Comments Submitted

To: Marge Schmuckal; Dan Goyette; David Margolis-Pineo; Tom Errico; Keith Gautreau; Jeff Tarling
From: Jean Fraser
Date: August 19, 2009

Application ID #: 2008-0064
Project Name: 2 units added to grandfathered existing unit (not subdivision)
Project Address: 38 Morse Street
COMMENTS PLEASE: Aug 26, 2009

**SITE PLAN**  
AT  
38 MORSE STREET, PORTLAND, MAINE  
MADE FOR  
**ROBERT C. NELSON**  
47 ALICE COURT, PORTLAND, MAINE

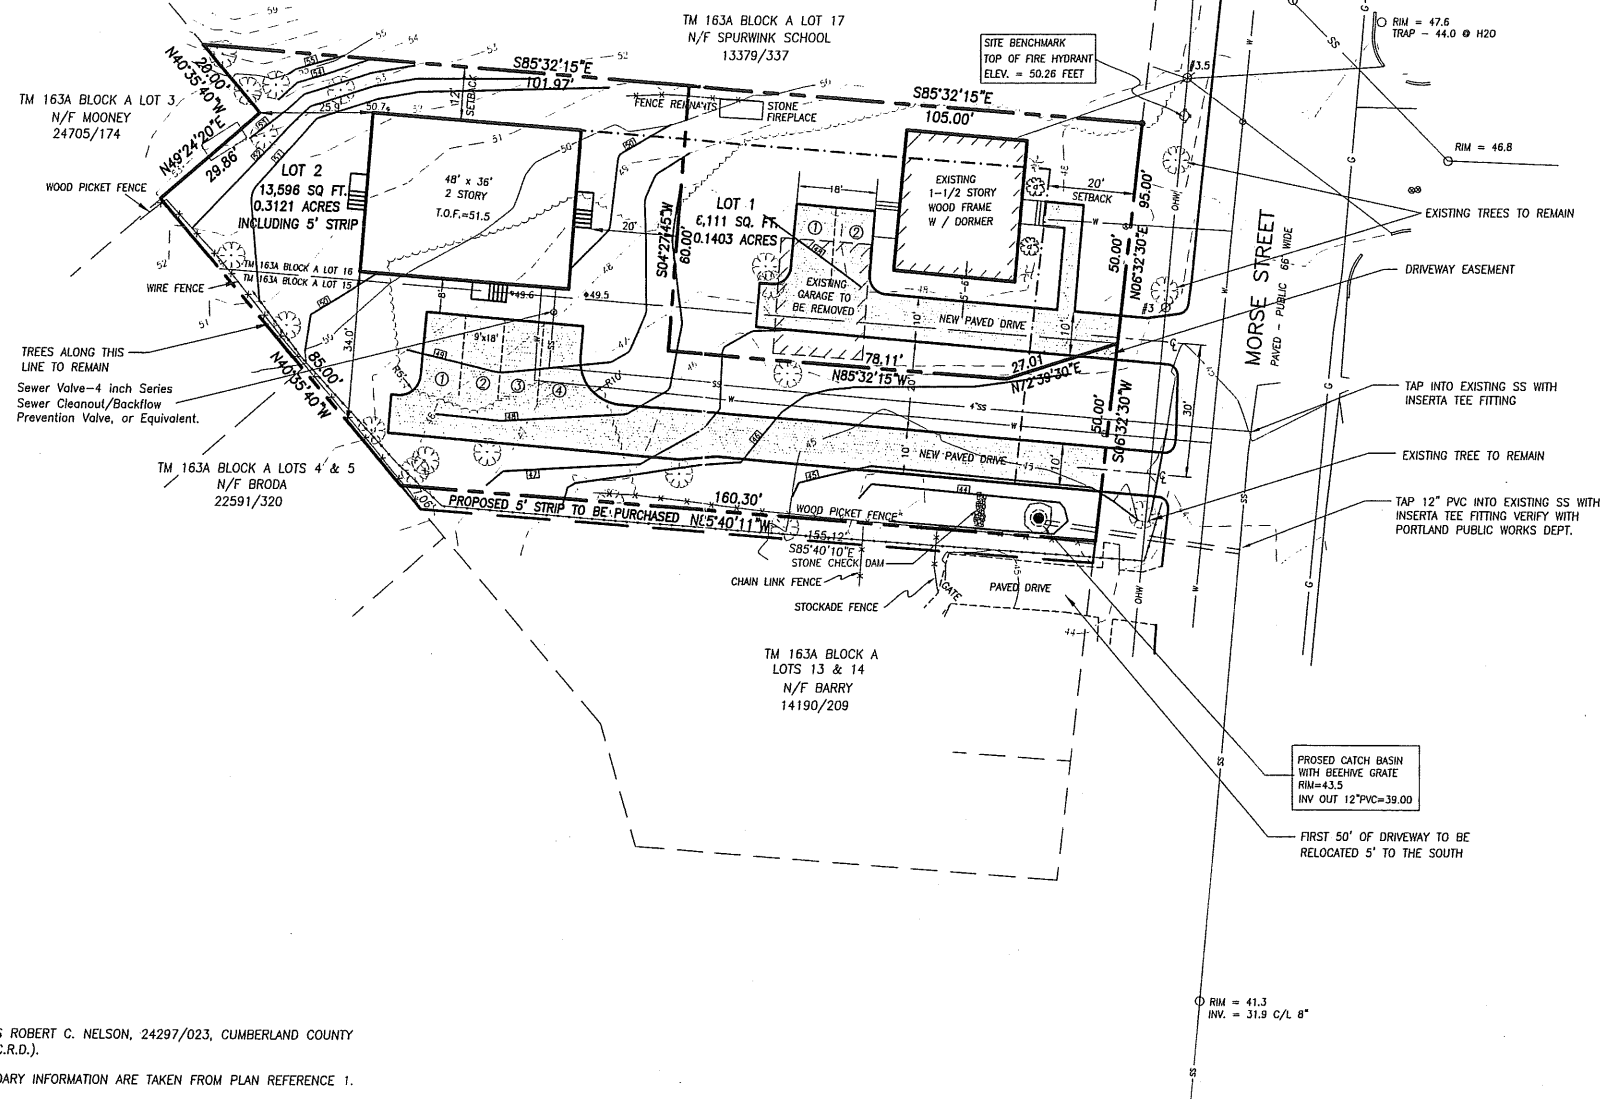
- Parking:** The zoning requirement for this proposal is 6 spaces and your plan shows 7 spaces, which is excessive in this residential area. Please omit the parking space nearest to the street.
- Drainage:** The storm water lines should be tied together on the property and connect to the proposed catch basin. An 8" pvc line should be installed from the catch basin into the street. The outlet pipe should be fitted with a 4" orifice plate inside of the catch basin. The 8" outlet pipe should be laid at a slope of .01.

The sanitary sewer lines from the two new units should be tied together at the property line with one connection into the street sewer line. Please have the Engineer stamp the plans and cross-reference the engineering details to the Site Plan; it would also be helpful if the plans were dated so they can be referenced in correspondence.

- Landscaping:** The locations, sizes and species of all planting should be shown on the Site Plan or in a separate Landscape Plan. Two street trees along the street frontage and two foundation plantings are required FOR EACH UNIT along with trees/shrubs/fencing to meet the City's Site Plan Ordinance (14-526 (15) which includes the following requirements:

- Driveway:** The driveway access width, parking aisle and parking space dimensions do not meet City standards. The Traffic Engineering Reviewer supports waivers for the aisle width and the parking space dimensions, but requires the driveway width to be increased to 16 feet (currently 9 feet).
